**RE: Volcano Mesa at The Trails
Grading Plan & Drainage Report
Engineer's Stamp Date: 11/16/21
Hydrology File: C18D088**

Based upon the information provided in your submittal received 12/02/2021, the Grading Plan & Drainage Report **are not** approved for Work Order and Grading Permit. The following comments need to be addressed for approval of the above referenced project:

Sheet 6 of 29

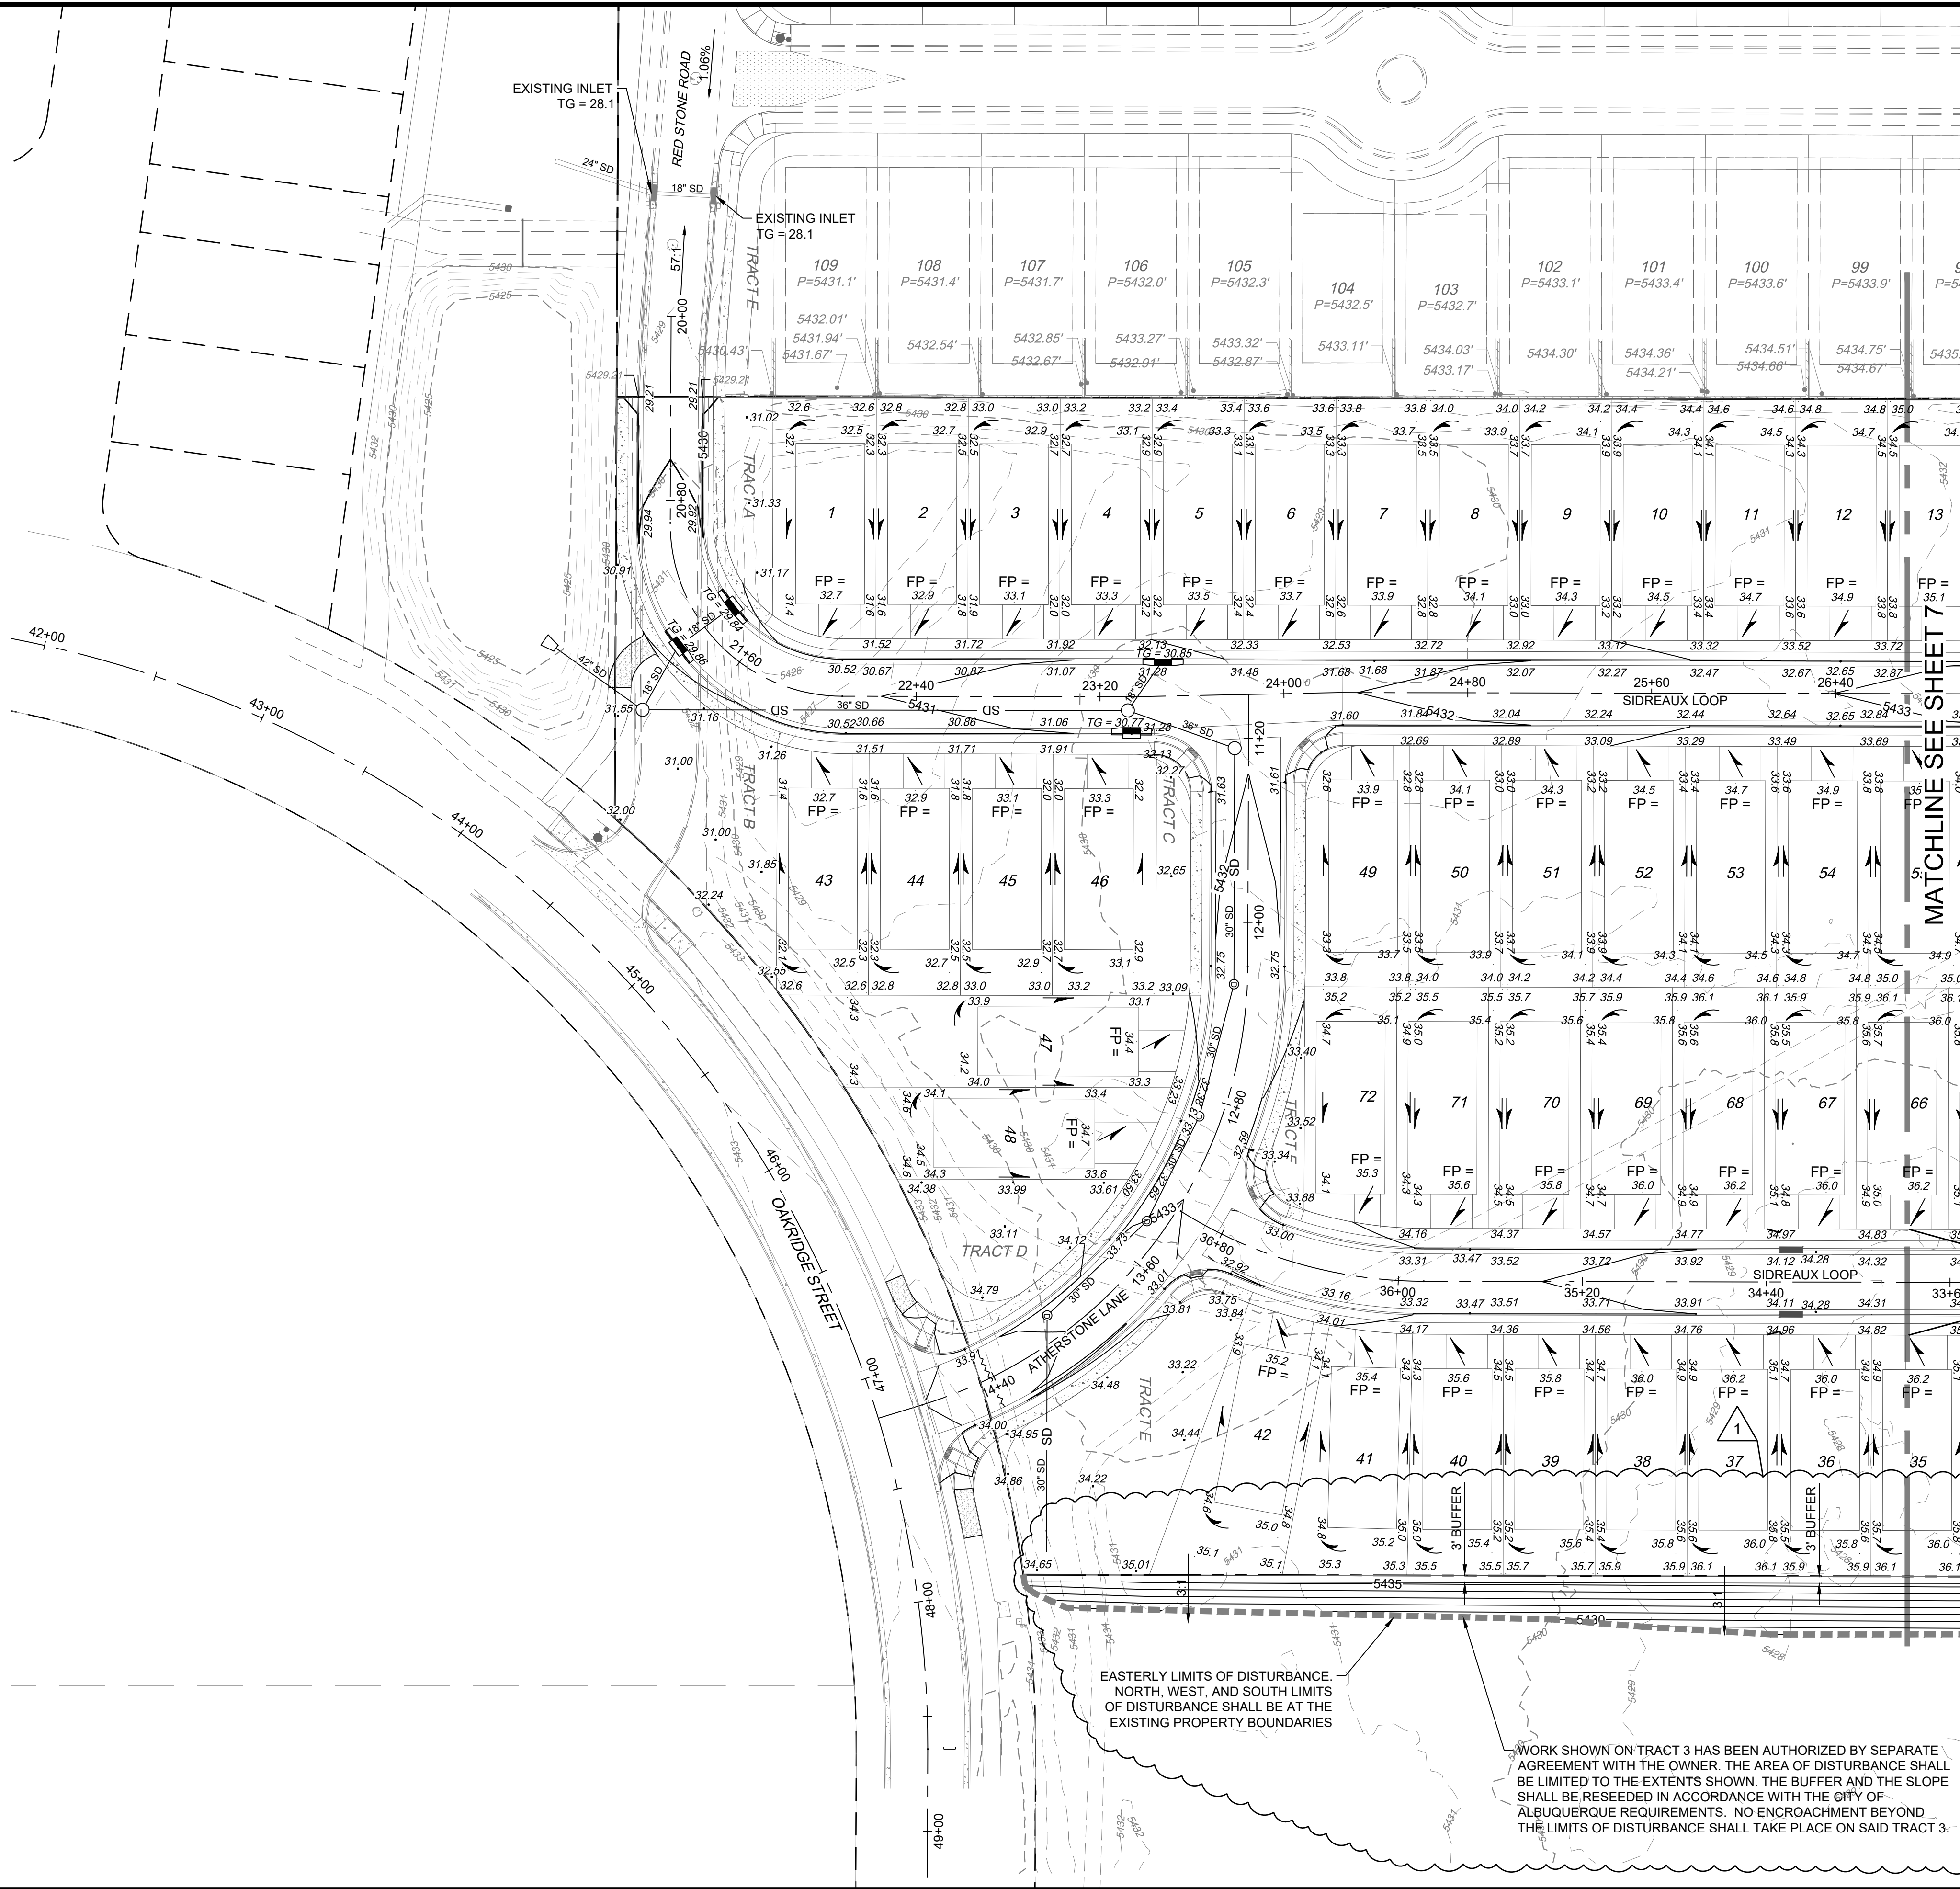
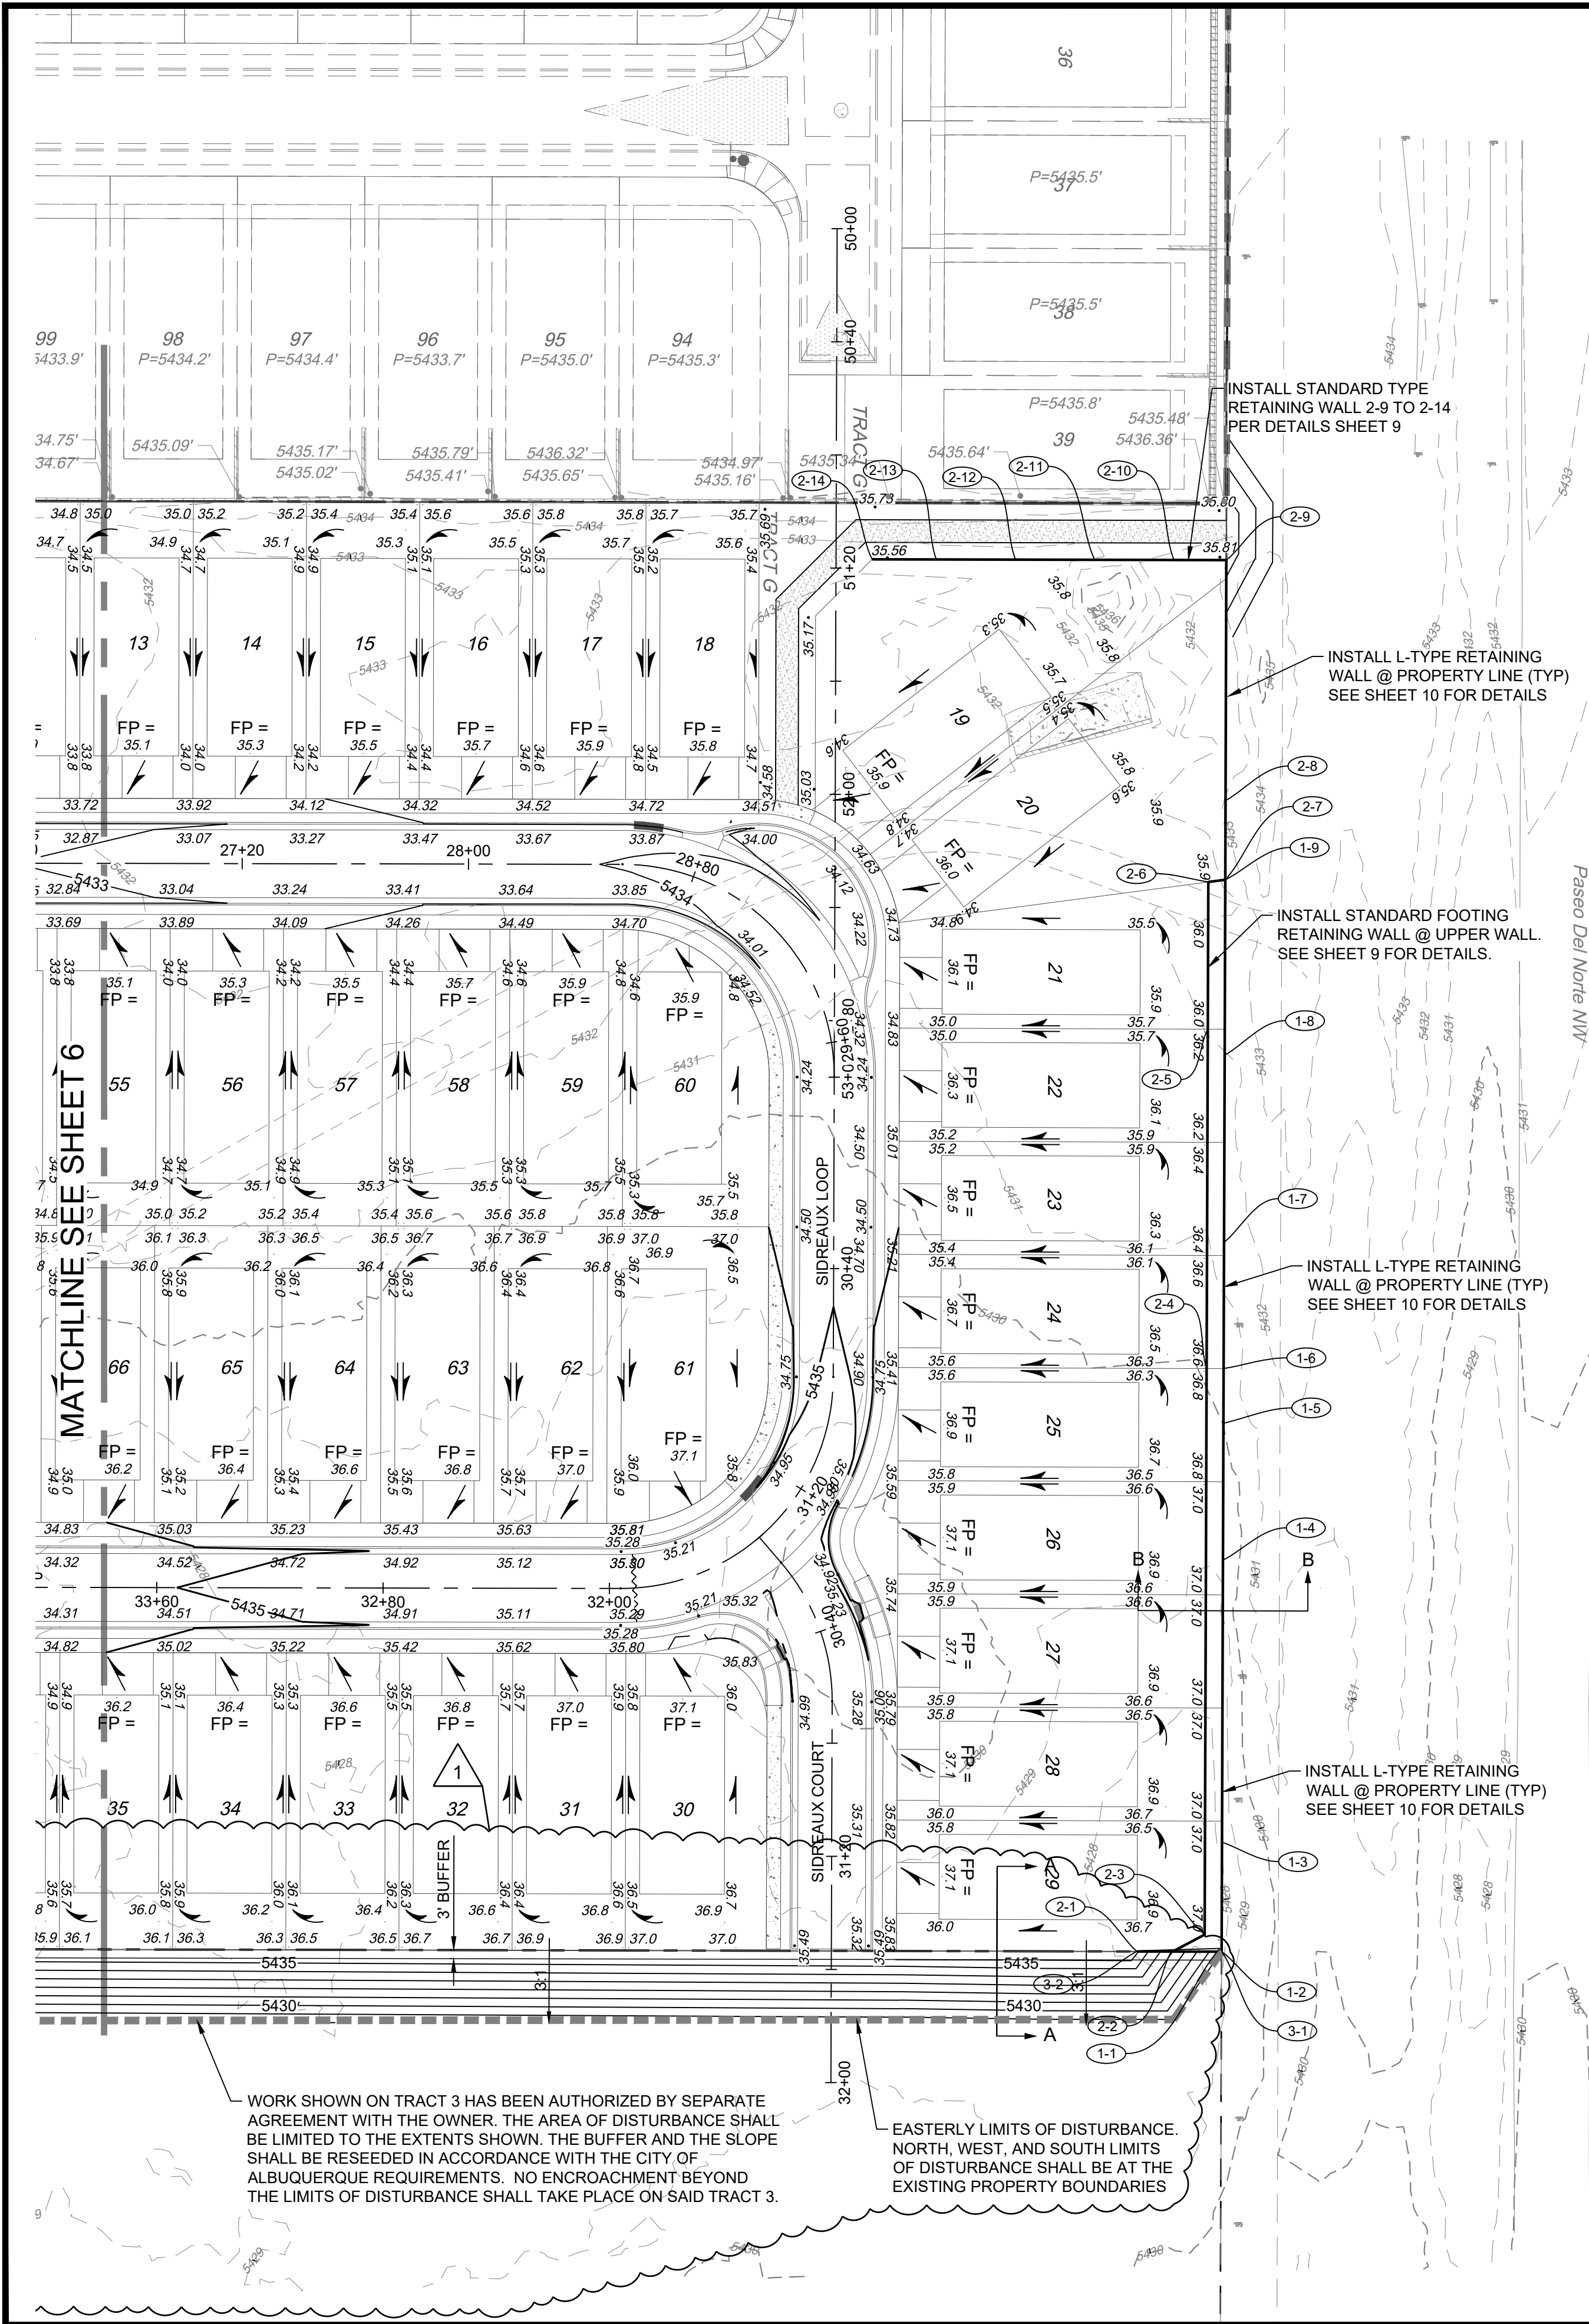
1. Please show additional grades as shown.

- Also, please add the proposed inlets and storm sewer. Please provide just the flowline at the inlets and the pipe size. The actual build information will be in the Work Order construction set. Please see example below.
